KIRKLEES METROPOLITAN COUNCIL INVESTMENT & REGENERATION SERVICE

DELEGATED DECISION FOR DISCHARGE OF CONDITION AA.2(3) - NOTIFICATION OF ENLARGEMENT OF A DWELLINGHOUSE BY CONSTRUCTION OF ADDITIONAL STOREYS

Reference no.	2021/CL/90160/W
Site Address	23, White Wells Gardens, Scholes, Holmfirth, HD9 1TZ
Description	Prior approval for enlargement of dwellinghouse by erection of additional storey
Recommending Officer	Laura Yeadon

PROPOSED ELEVATION FACING SOUTHEAS

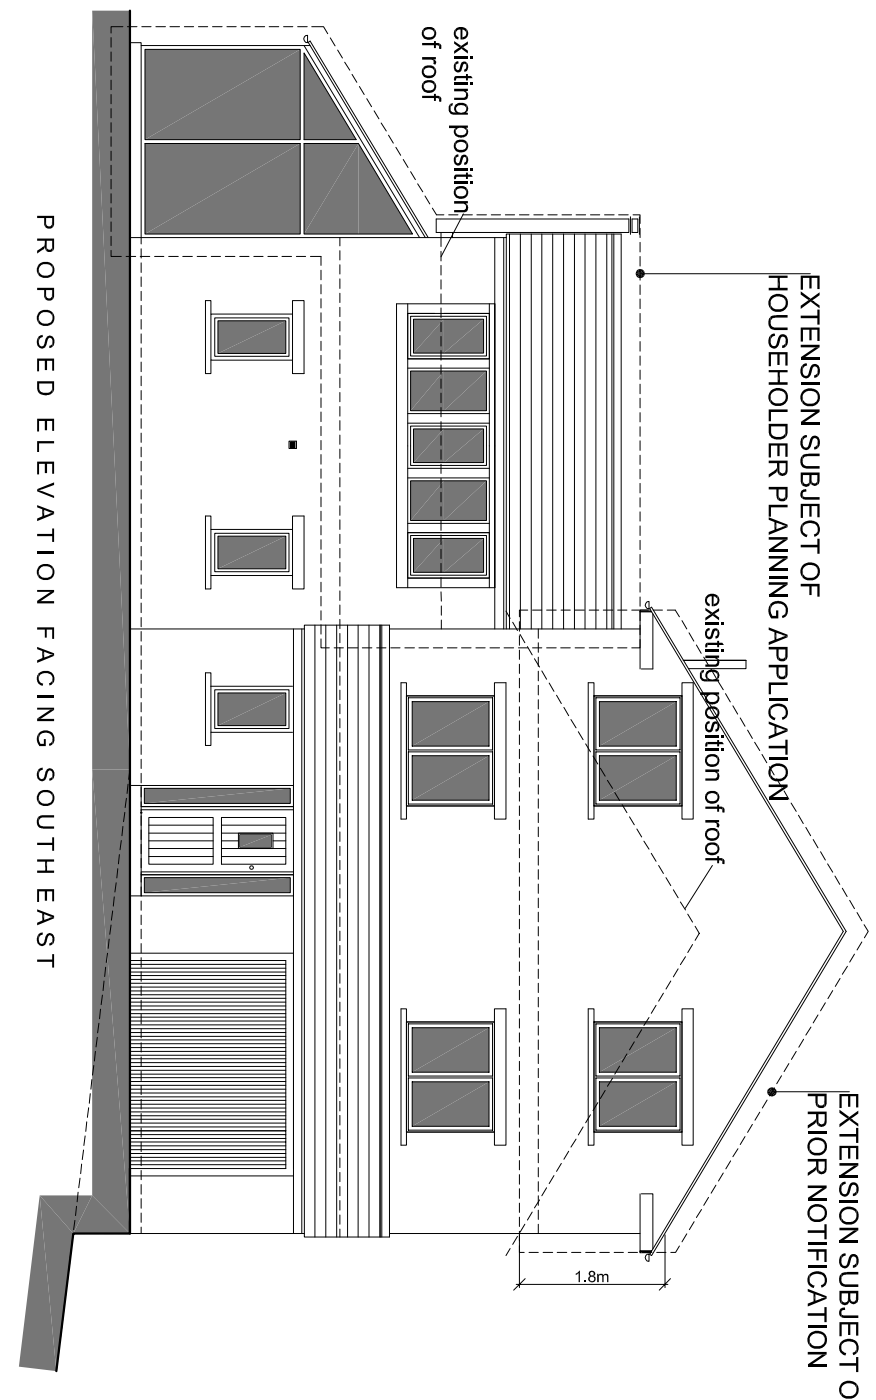
9.9 In terms of the impact of the scheme on the external appearance of the principal elevation of the property. In this instance, this would result in openings being included within the second storey of the property. These would be aligned with the openings at first floor and therefore considered acceptable and consistent with Local Plan Policy LP24 and advice within the NPPF.

PROPOSED ELEVATION FACING NORTH WEST

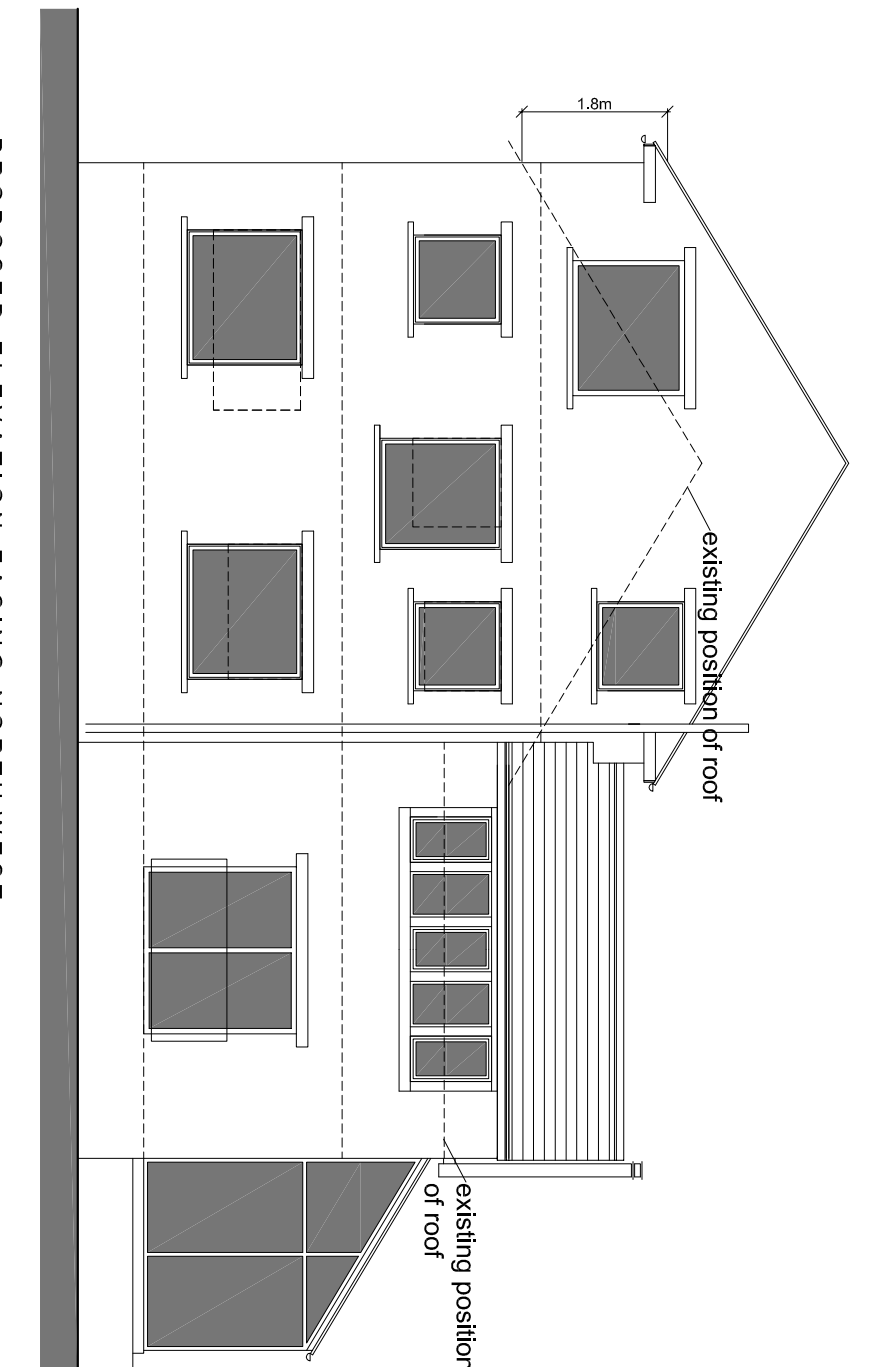
Notwithstanding the submitted details, the development approved does not extend to the two rooflights on the west facing roof slope as shown on drawing number 20.040(2-)002 Rev A.

9.10 The side elevation of the property would also face a highway the therefore also is required to be considered. The proposed side elevation contains no openings other than rooflights within the roofspace. Condition AA.1(b) states that*"the development must not include a window in any wall or roof slope forming a side elevation of the dwellinghouse;"*. As such, a condition can be attached to the decision notice omitting these details.

Notwithstanding the submitted details, the development approved does not extend to the two rooflights on the west facing roof slope as shown on drawing number 20.040(2-)002 Rev:A.
